Landscape Briefing Note 5

Project: 1080 East Anglia One North and East Anglia Two
Date: 10th January 2021
Purpose: Notes responding to SPR's Deadline 3 submissions
Reference: 1080 BN05 Deadline 3 Responses Final R1.docx

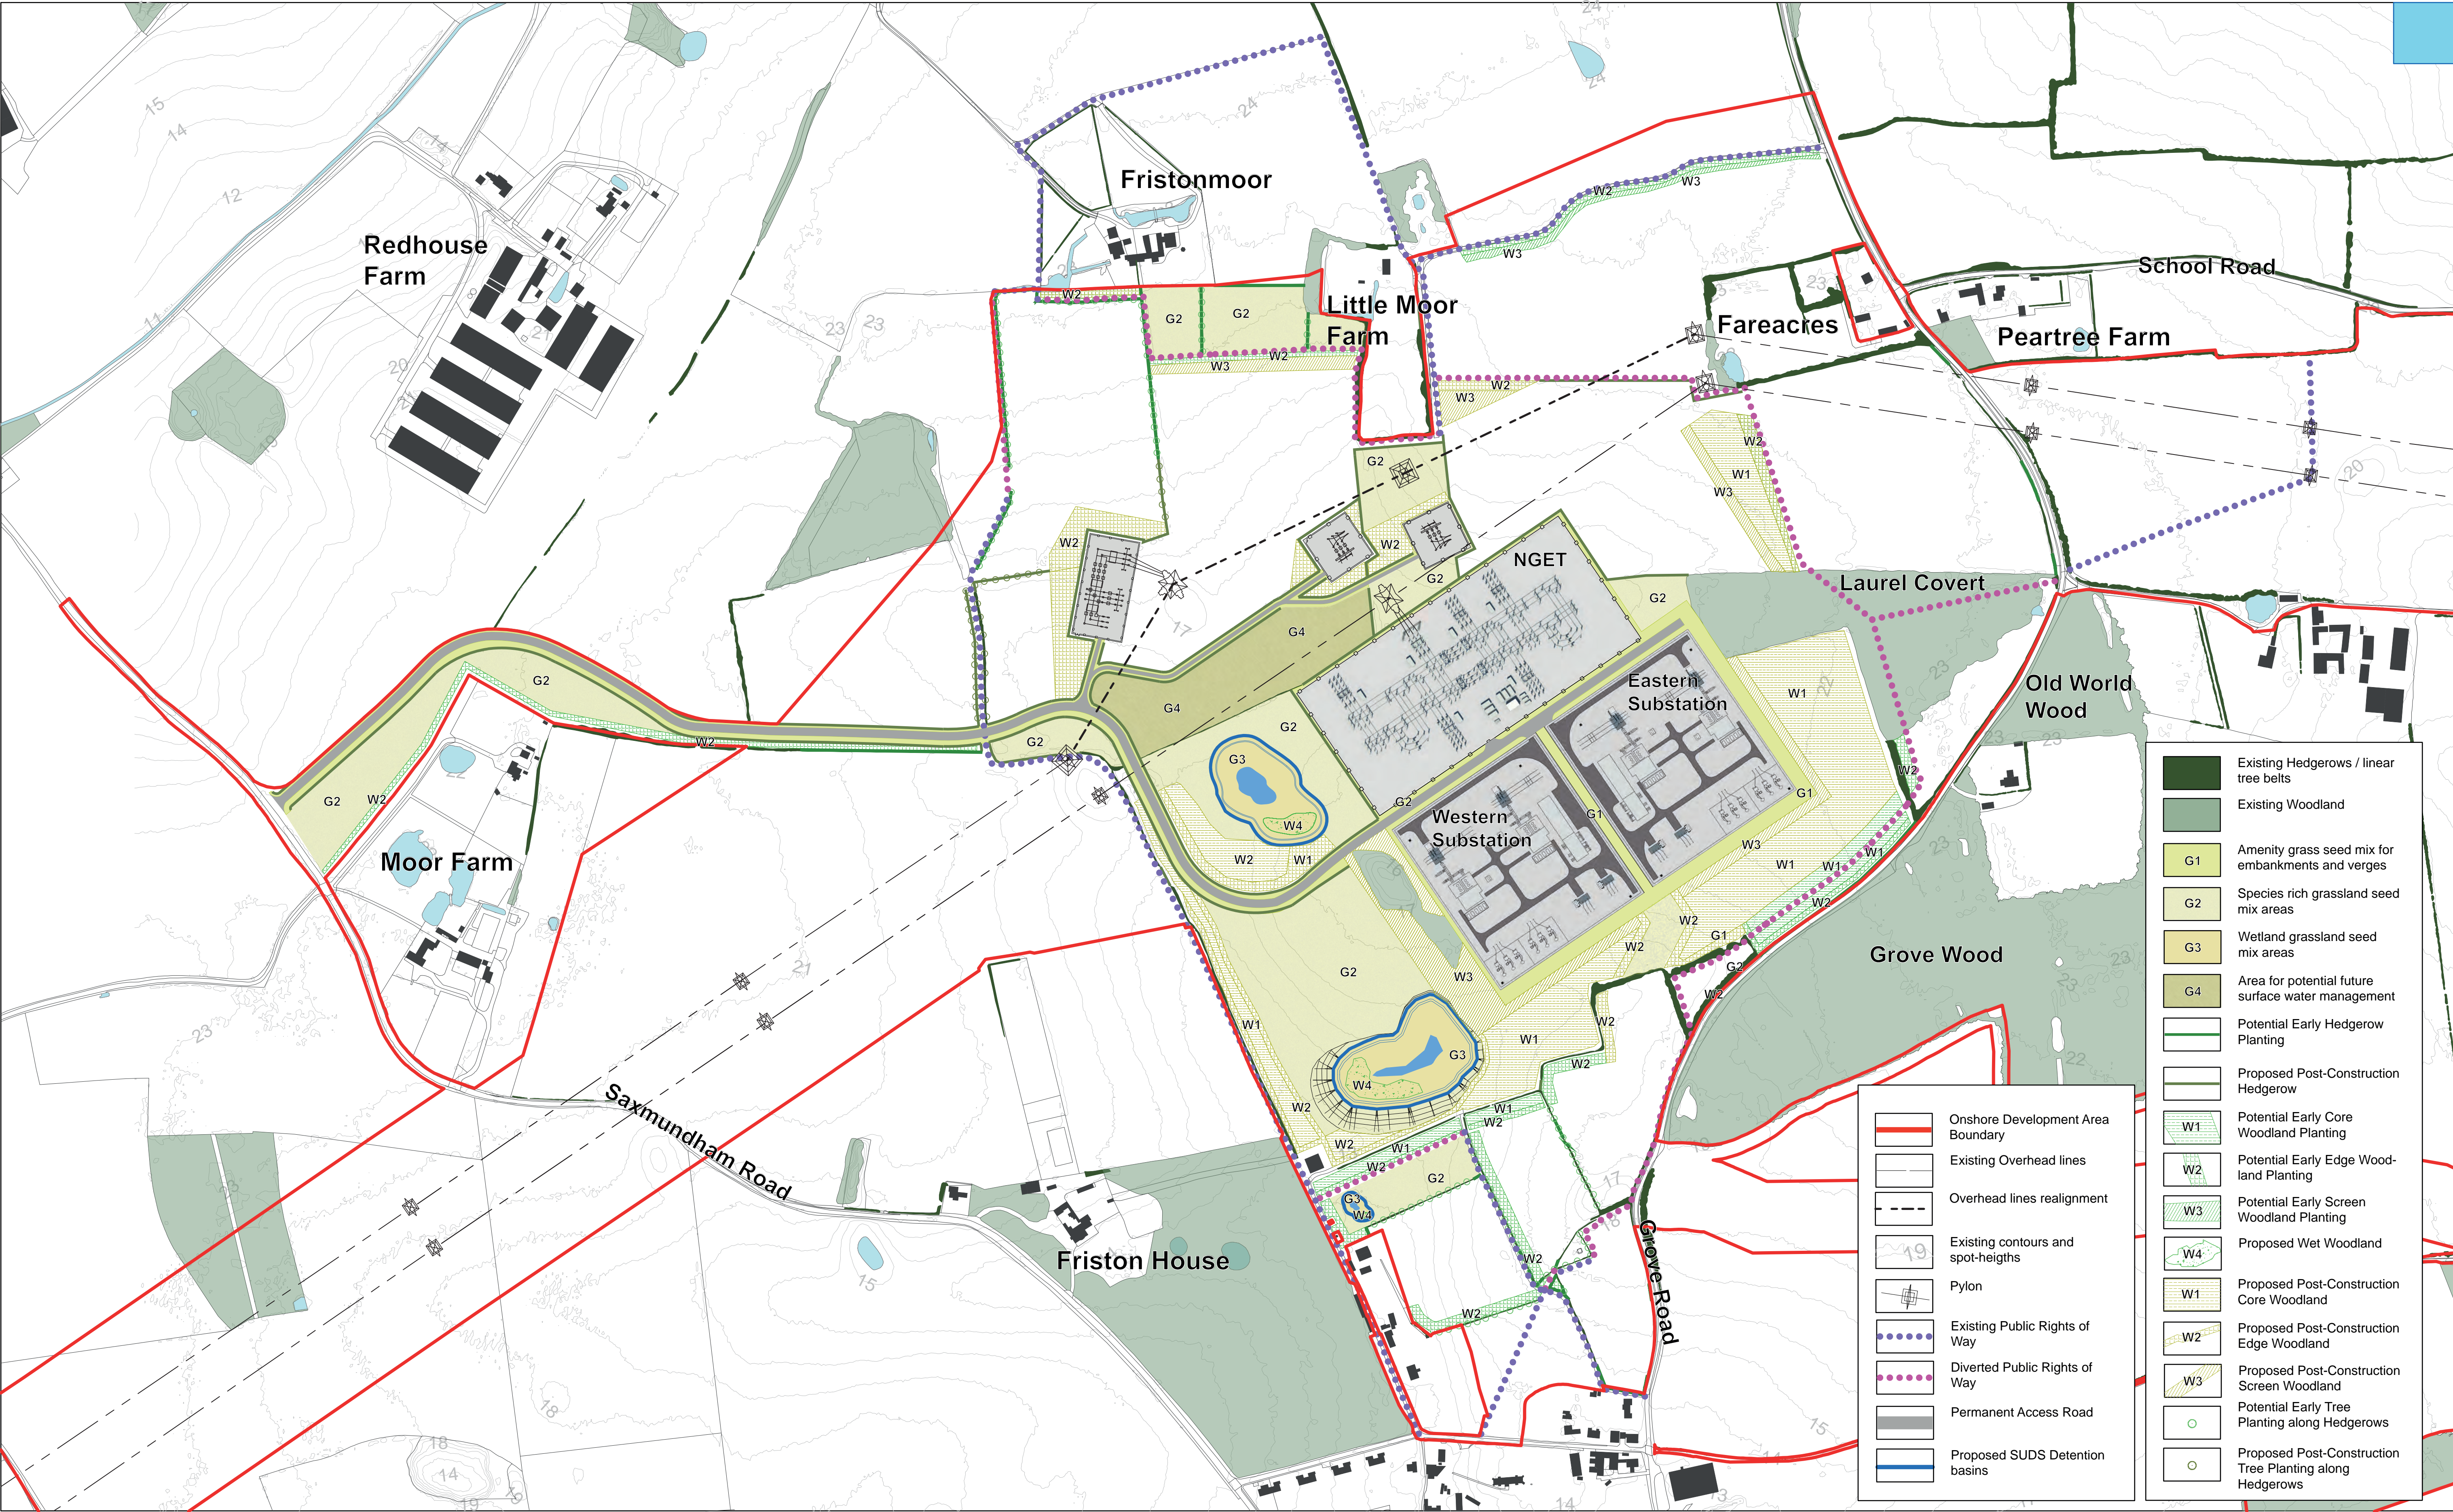
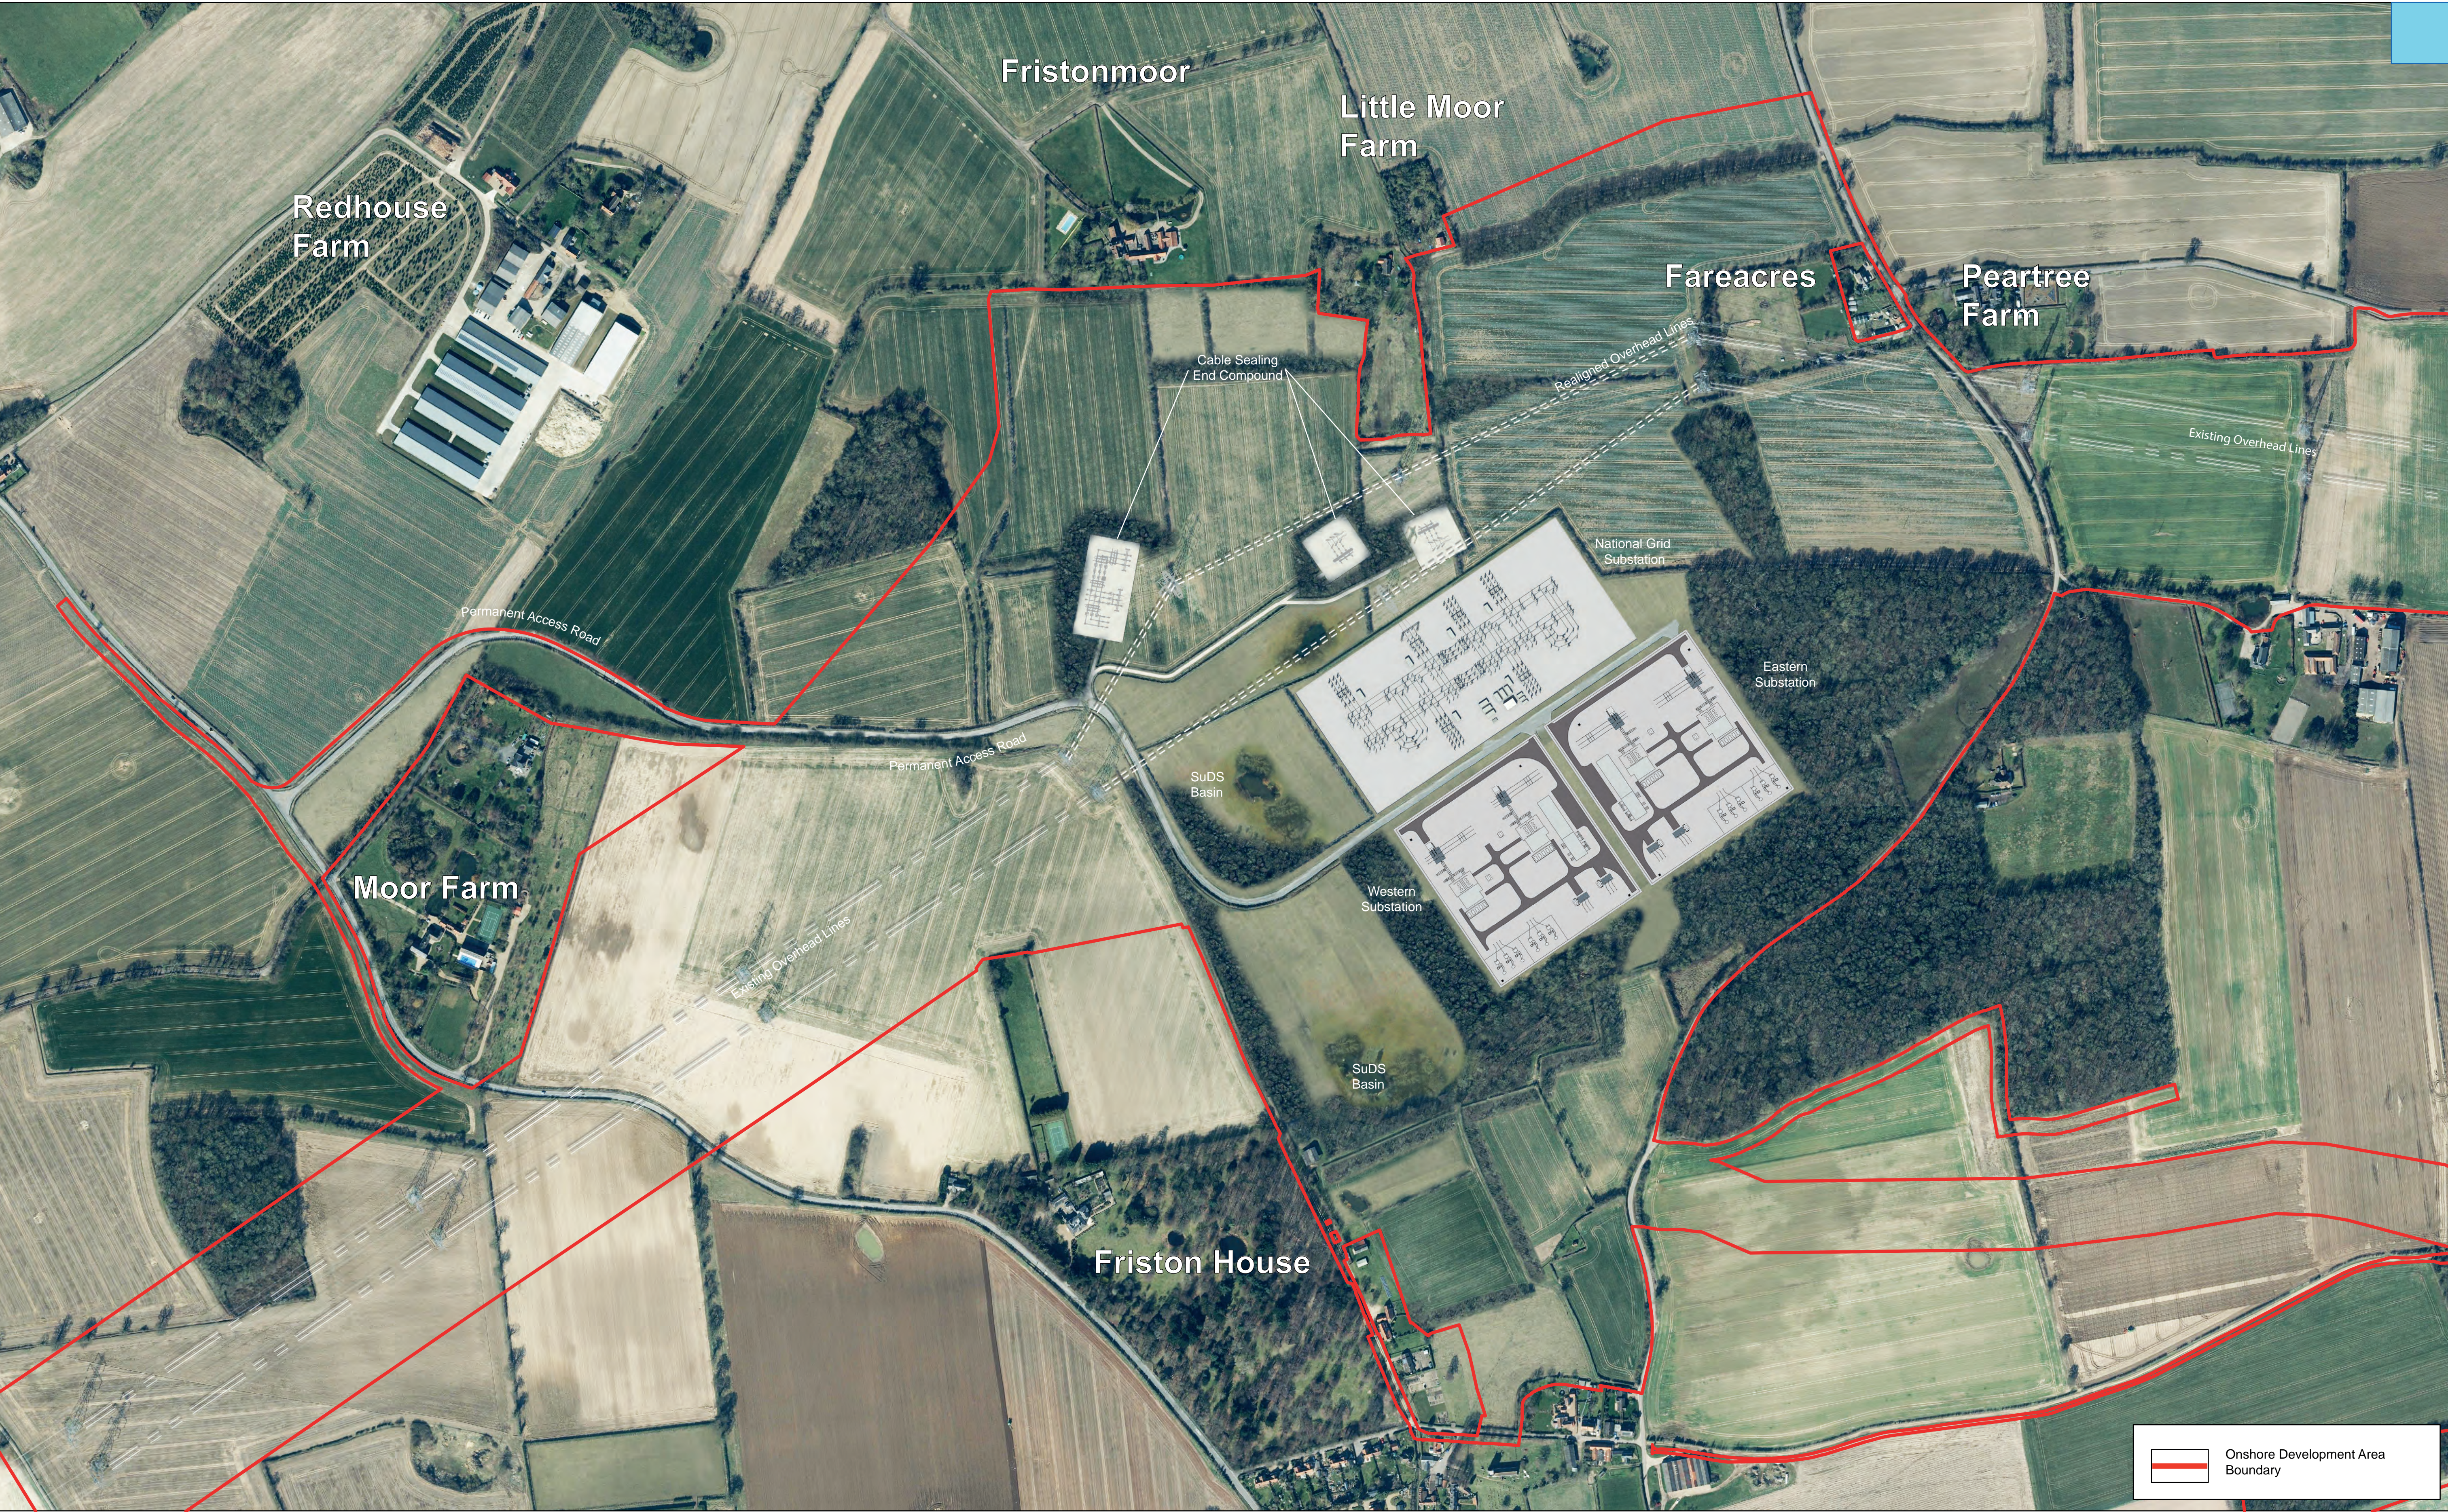
-
4. Page 15 of EN010077-003309-ExA.AS-11.D3.V1 EA1N&EA2 Onshore Substations Update Clarification Note includes Plate 5.2: *3D model of the updated easternmost onshore substation showing reduced footprint and building / equipment parameters*. A model showing both substations would be useful because previously it had been indicated (in the submitted OLMP General Arrangement drawing, Figure 3) that the substations would be ‘mirrored’ rather than repeated.

5. Plate 5.2 does not provide any indication of the orientation of the eastern SPR substation. It is only possible to understand the orientation by reference to the revised OLMP General Arrangement drawing, Figure 3¹. This shows the Super Grid Transformers and associated equipment located along the north west facing edge of the substation. Assuming this represents the orientation of the eastern substation, Plate 5.2 would be more easily understood if it was rotated 90° clockwise so that the top corner of the model represented the northernmost point of the eastern substation. It has also been inferred from the OLMP General Arrangement drawing that the western SPR substation continues to be a mirror of the eastern substation.

6. On this understanding I assume ‘access road’ means the access point into the substation. There are two external access roads to the eastern SPR substation, one along the north west facing edge and one along the south west facing edge (the edge facing the western SPR substation). The access point is from the latter. It is not clear why the external access road along the north western edge of the eastern SPR substation is required at all.

28. The SPR substations in Figure 9 OLMP Illustrative Plan (GIS) appear to be larger than in the other plans and the planting around the Cable End Sealing Compounds is omitted. It is assumed that these are drafting errors.
